OAKHURST PROPERTIES LLC

November 14, 2013

Re: 330-338 Forest Avenue, Portland, Maine -- Sign Change Request

PARKING LOT ELEVATION

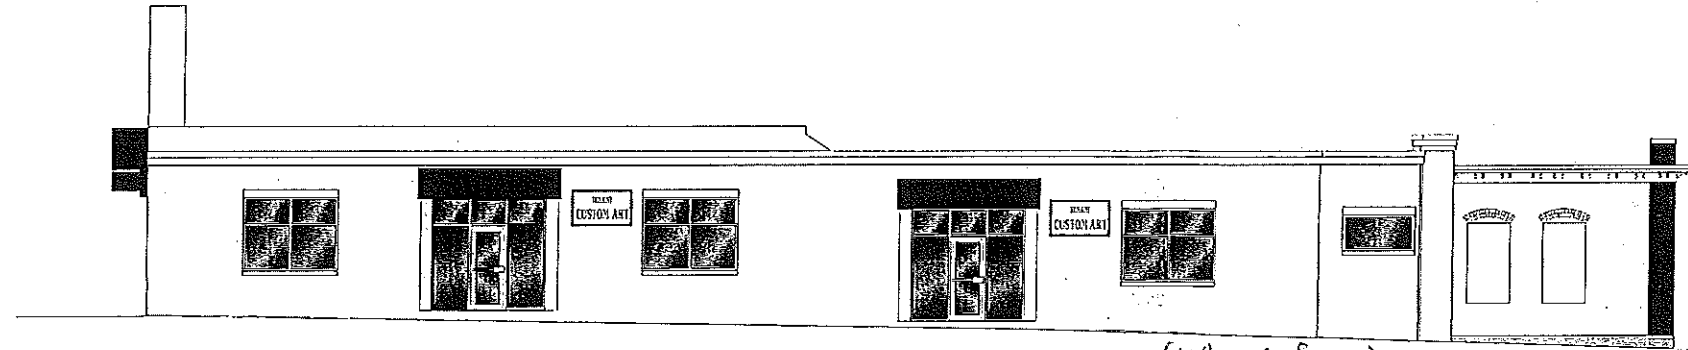
- 1.) Reduce the size of the sign permitted for Tenant of Unit #1 on the parking lot side of the building (please see the attached building plan) from the current 2'6" x 12' to dimensions that will be no greater than 25 SF (i.e. a maximum of either 2'6" x 10'0" or 2'0" x 12'6"). This signage is currently not in place and not utilized by the Unit #1 Tenant, however, we wish to have this option reserved and available for future use. The existing signage of the Unit #1 Tenant, on the Forest Avenue side of the building, shall remain unchanged.

- 2.) Allow an incoming Tenant of Unit #3 to add a 4th sign to the parking lot side of the building, which measures 3' x 7'. (With this change, along with the modification noted in #1 above, the total square footage of signage on that side of the building will be less than the total 106.5 SF allowed.)

ENTRANCE TO UNIT #3
(1) 2'-6" X 12'-0" (VARIES TO BE FILED SURVEYED) X 3'-0" FABRIC AWNINGS
(1) S.F. 2'6" X 6" INTERNALLY ILLUMINATED SIGN 15sf
DURHAM STREET ELEVATION

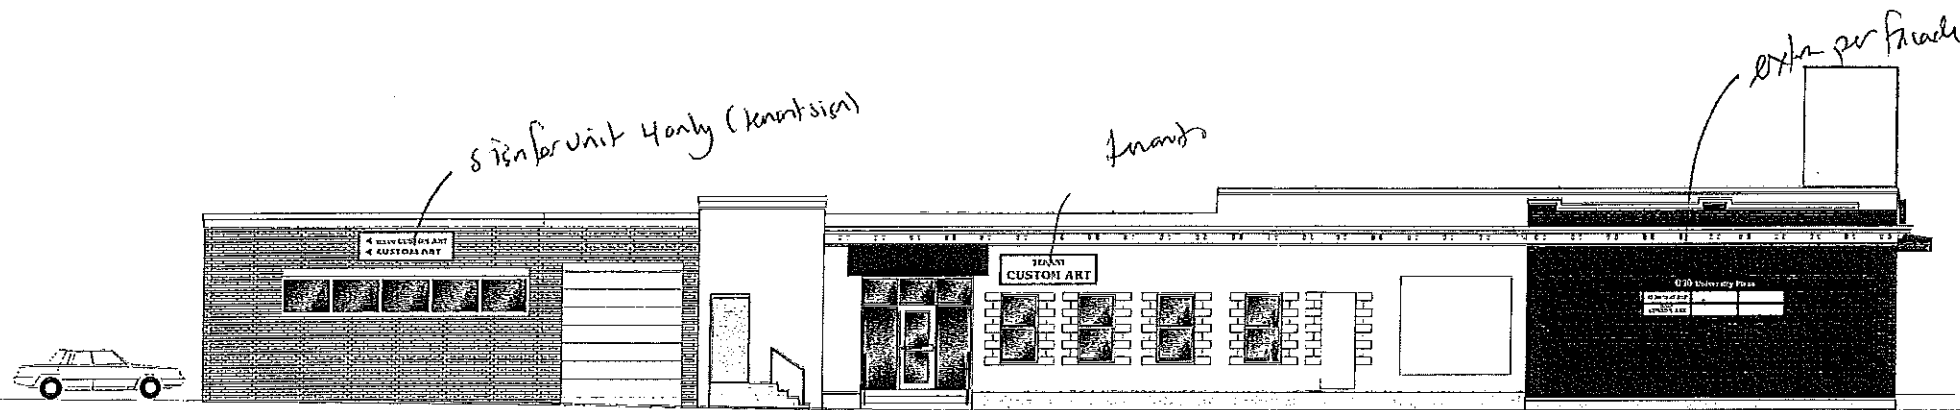
- 3.) Change the dimensions of the two signs approved for the end wall of the building (facing Durham Street) from 3'0" x 5'0" to 2'6" x 6'0" (total signage square footage remains unchanged; this conforms to the existing sign already in place for the Tenant of Unit #4).
